# SEVEN LAKES ENGINEERING SERVICES, INC.

October 18, 2022

Subject: Structural Assessment  
54 Edes Ct.  
Cameron, NC 28326

MONOLITHIC SLAB

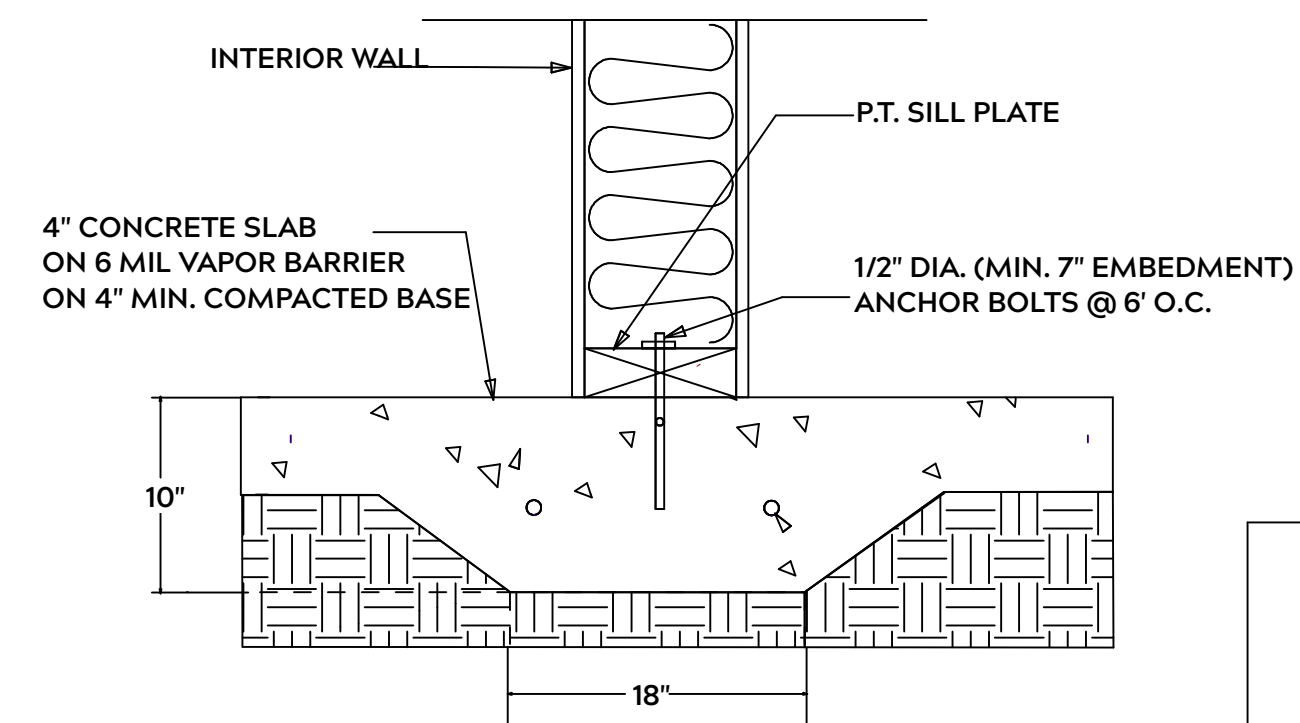
Upon inspection of the subject home, SLES noted that the interior load bearing wall between the great room and the bedroom on the first floor is missing a lug footer. The reinforced lug footer is designed to carry the load of the second story floor system. SLES also noted that the sill plate located in the garage is not sitting properly on the concrete slab.

SLES recommends that the second story floor be temporarily supported in order to cut a section of the concrete slab out for the installation of the proposed footer. Please refer to the attached drawing for more details. SLES also recommends that additional concrete be poured in the garage underneath the sill plate in question. Upon addressing both of these items, SLES will certify the repairs.
